CITY OF ALBUQUERQUE

March 22, 2013

**Re: Hampton Inn at the Sunport Grading and Drainage Plan
Based on Email Plan Received 03-22-2013 (M-15/D043)**

SECTION B-B
NTS

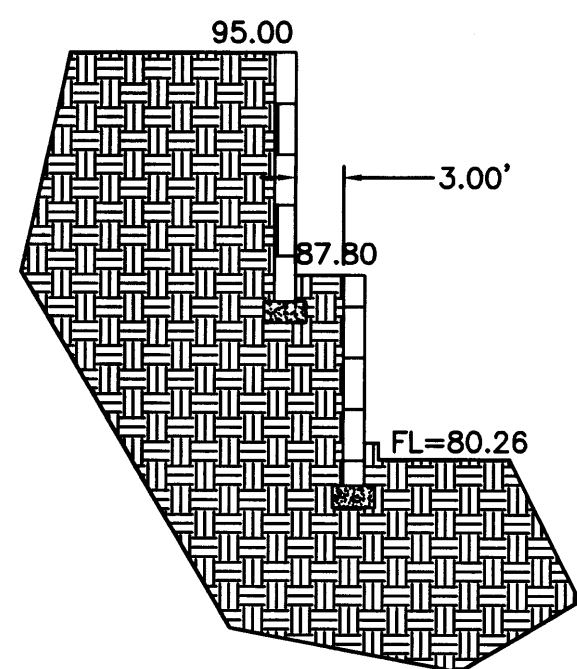
- The detail for Section B-B should include the curbing on the adjacent lot. How will falls be prevented from the top of this retaining wall?
- Section A-A needs to be moved further to the east so that it will show the proposed retaining wall.

ENGINEER'S SEAL	HAMPTON INN ® SUNPORT GRADING AND DRAINAGE PLAN	DRAWN BY WCWJ
		DATE 3-19-13
		21226-LAYOUT-7-05-12
DAVID SOULE P.E. #14522	 <i>Rio Grande Engineering</i> 1606 CENTRAL AVENUE SE SUITE 201 ALBUQUERQUE, NM 87108 (505) 872-0999	SHEET # — 21226

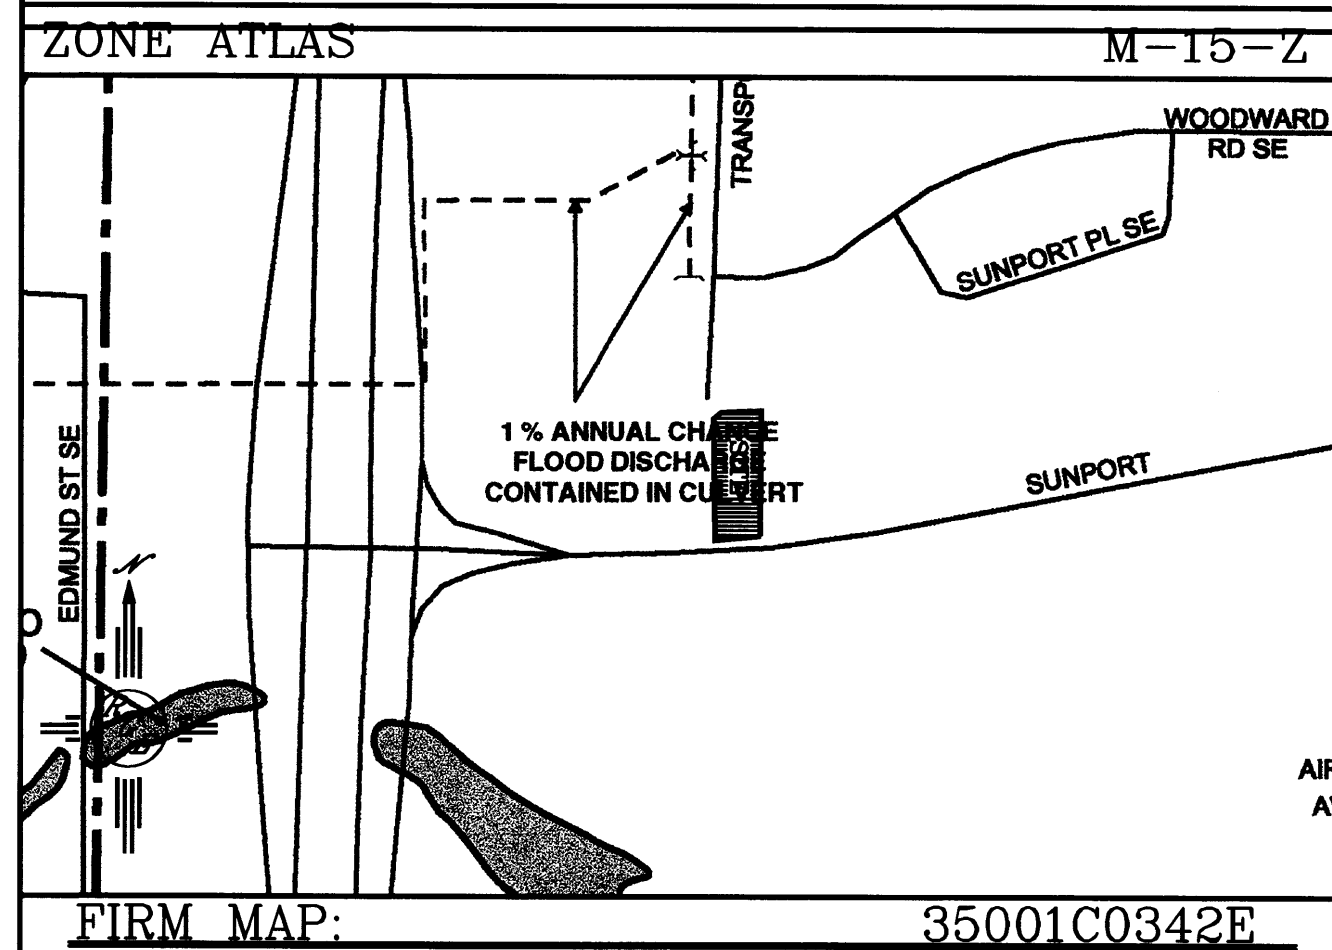
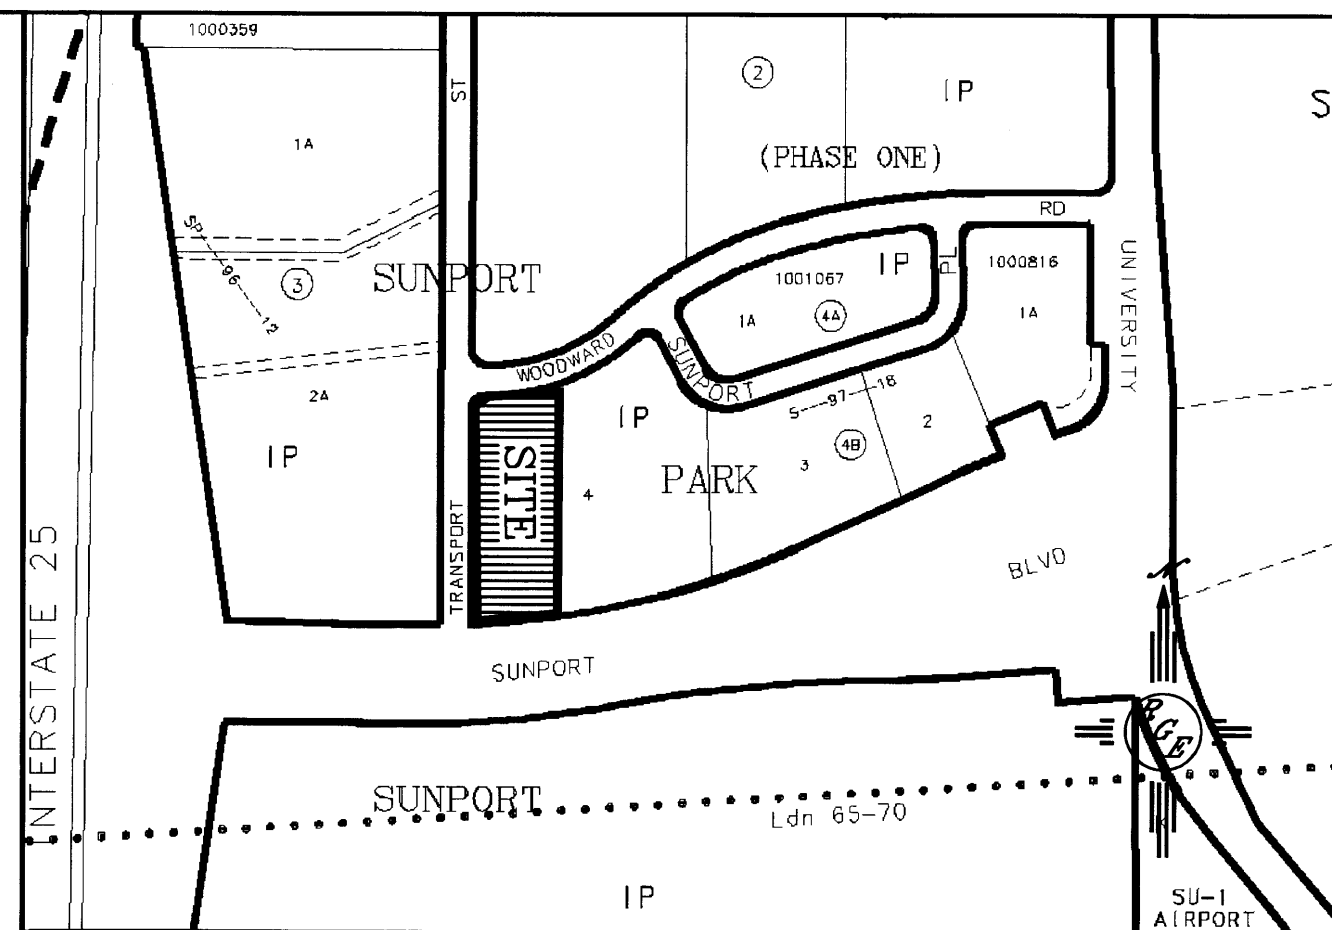
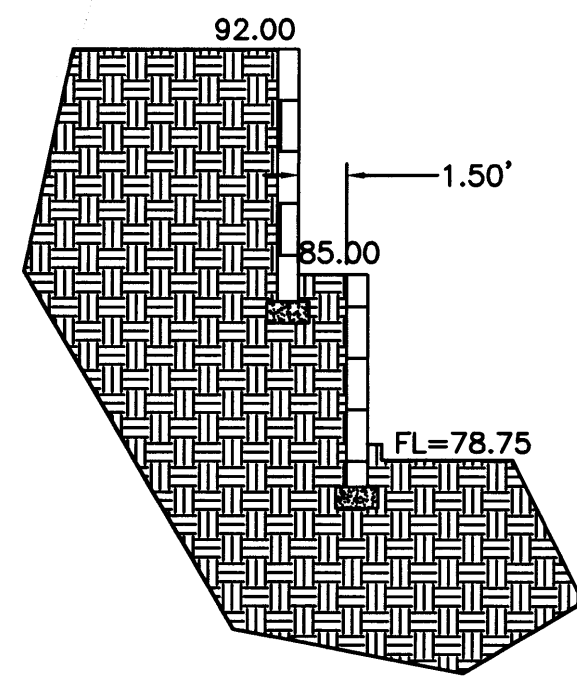
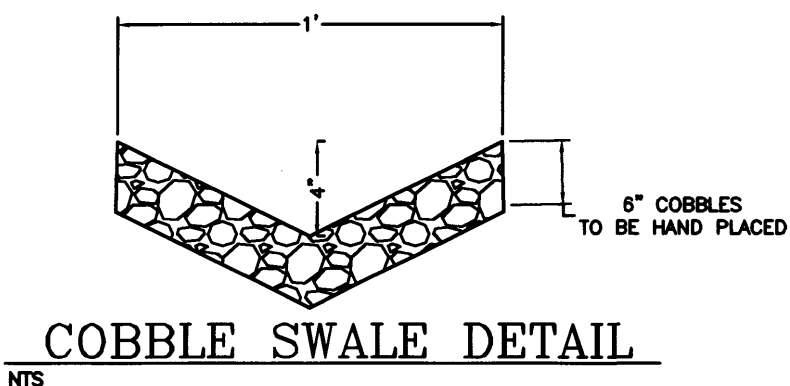
- Provide all proposed contours on the grading and drainage plan.
- Clearly show the existing channel detail along the southern project boundary.
- Show the construction easement(s) on the southern and western portions of the site on the grading plan. DMD has indicated they do not want any improvements in the construction easement to the south except for minor erosion control. A retaining wall within this easement is not acceptable.

- Clarify the location of the eastern retaining wall at the northern portion of the site. Will there be any clear-sight issues with the location of this wall?

- The benchmark designation for the project should be in NAVD 1988 coordinates. Clarify that plan elevations are correct.
- Show the location of the cobble swale on the grading plan or remove the detail if a swale is not needed.
- The topography shown for the adjacent lot does not accurately reflect what is present on satellite imagery.
